Oaklands Farm Solar Park

Consultation Report

Appendix 13.1 - Section 42 Copies of Responses and Summary of
Feedback and Regard Had

Document Reference: EN010122/APP/5.2

Trailer of HGV enters opposing lane on turn due to the angle of the bend.

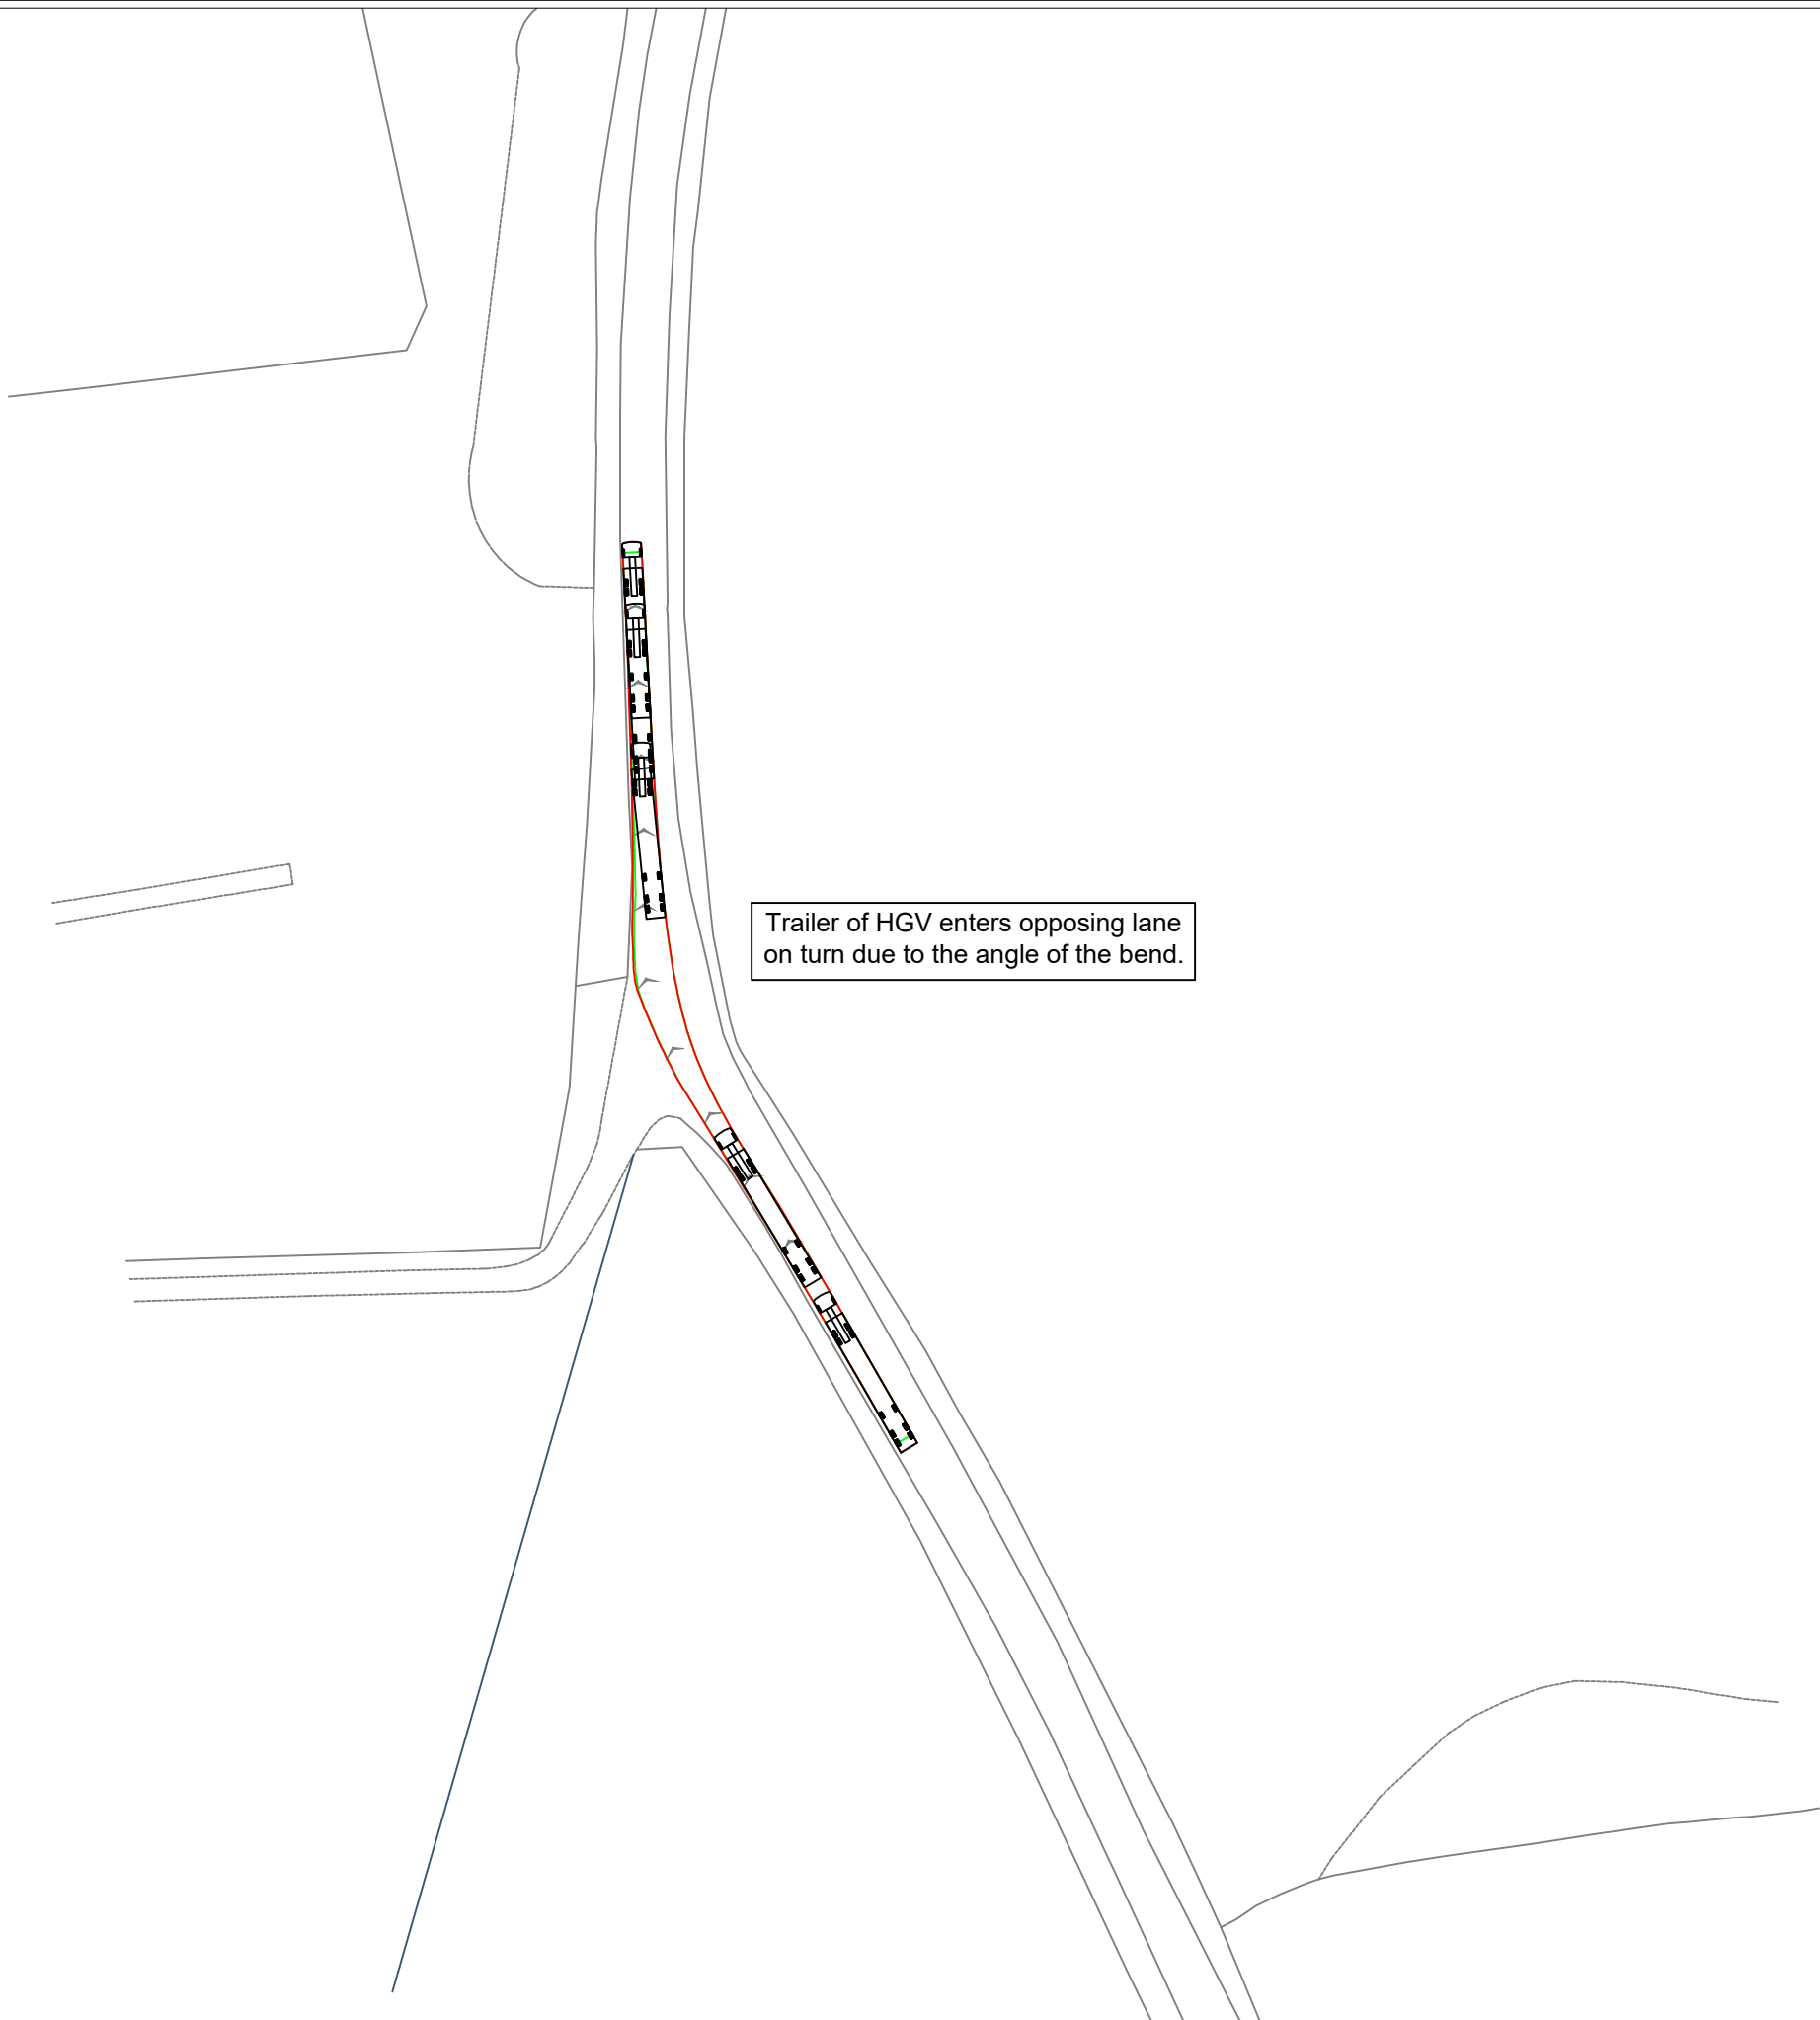
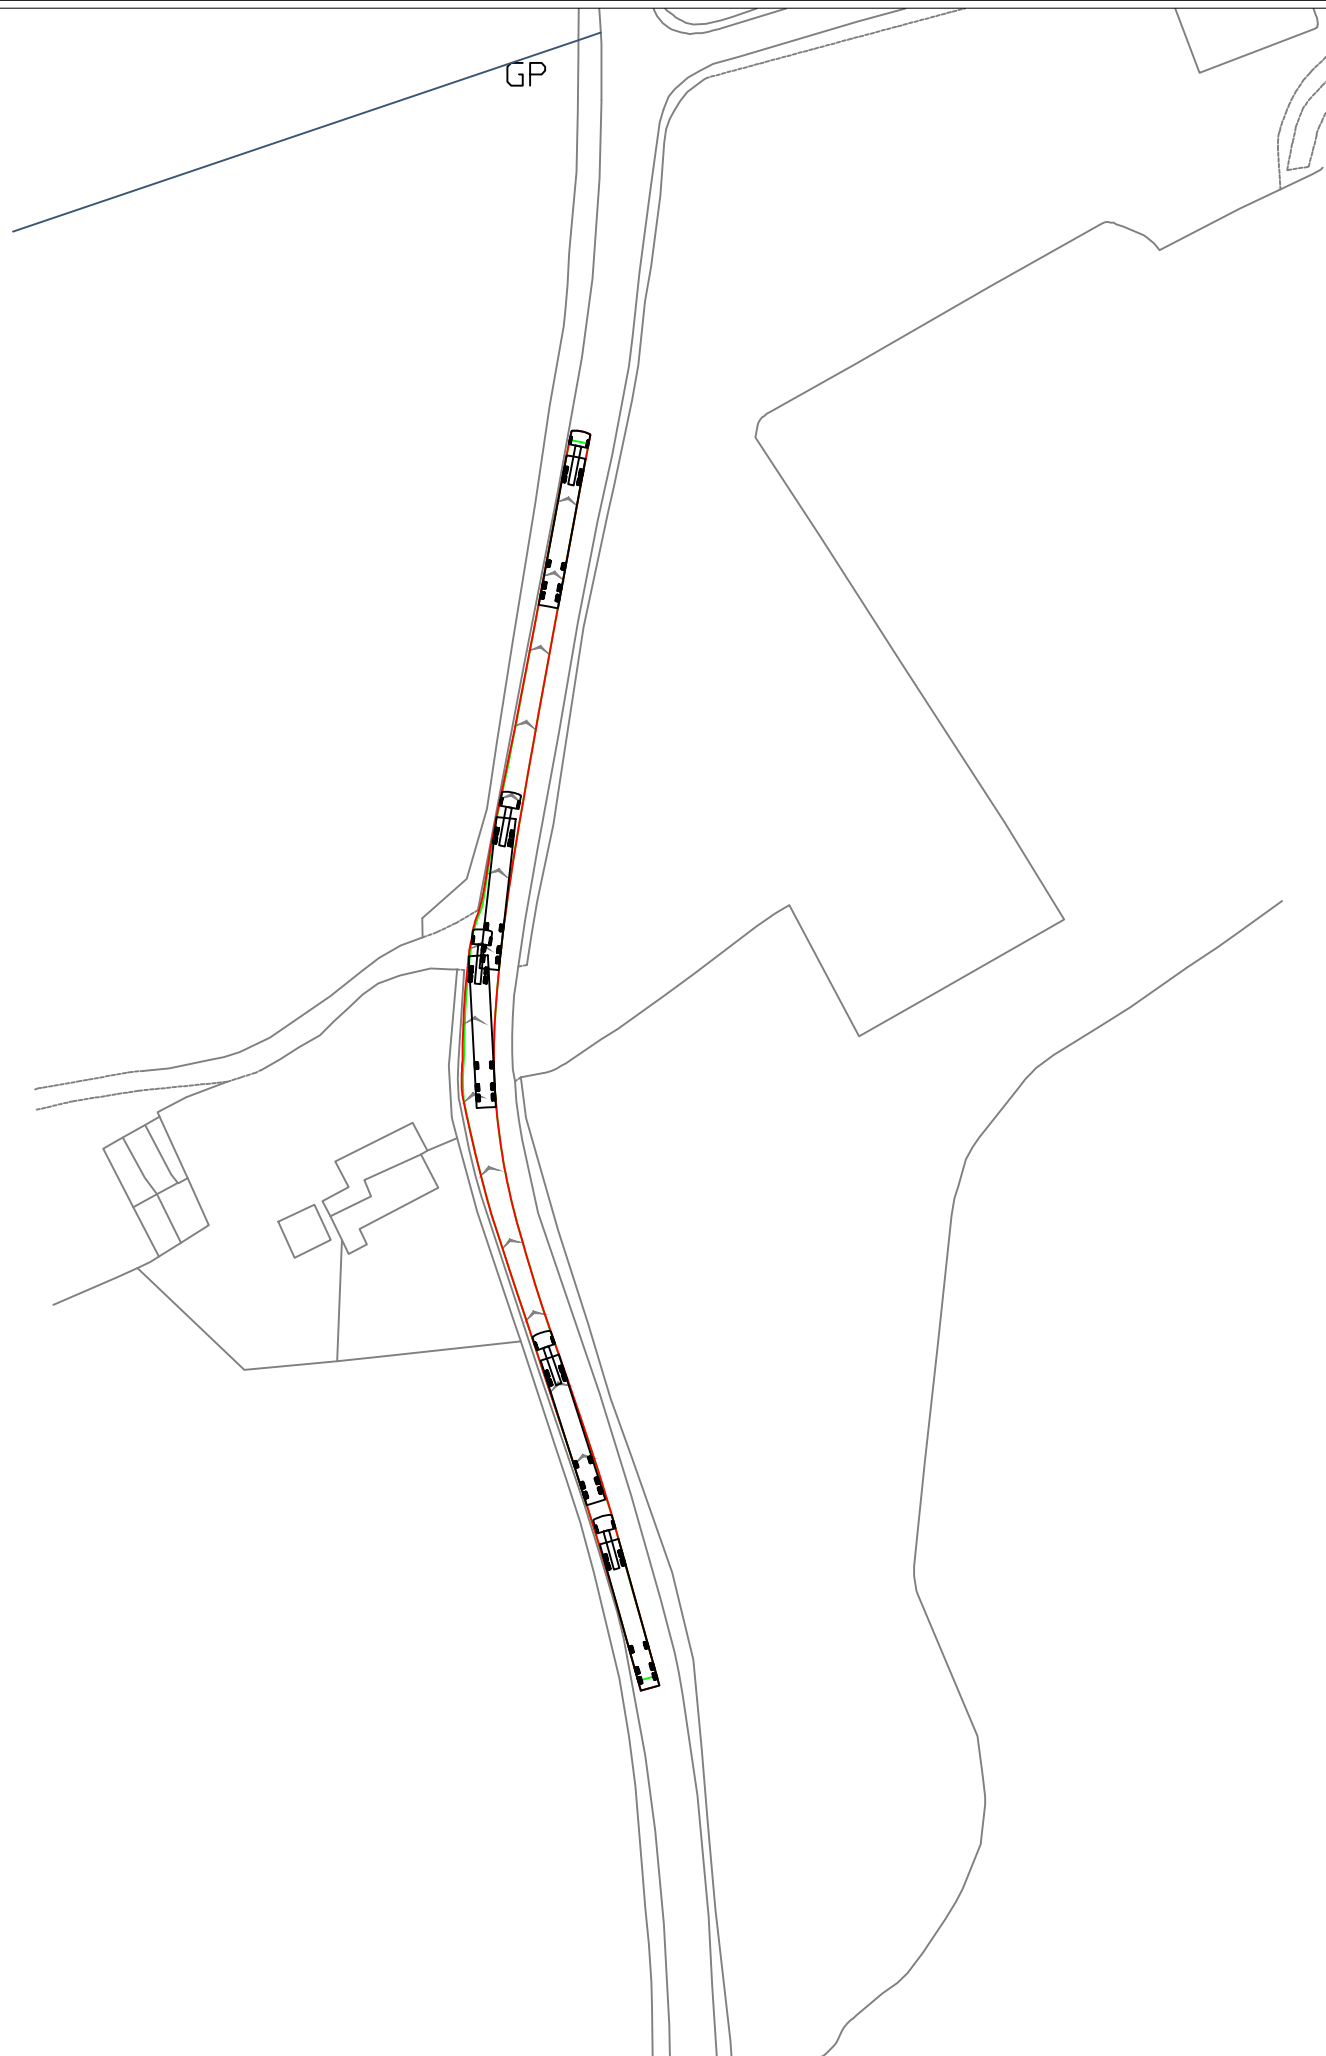
- Request for further information including swept path analysis of access points to the site to assess suitability or any highway safety concerns.
- The CEMP should clarify whether any safety issues should be considered during operation, although it is noted that vehicle movements at this point will be minimal.
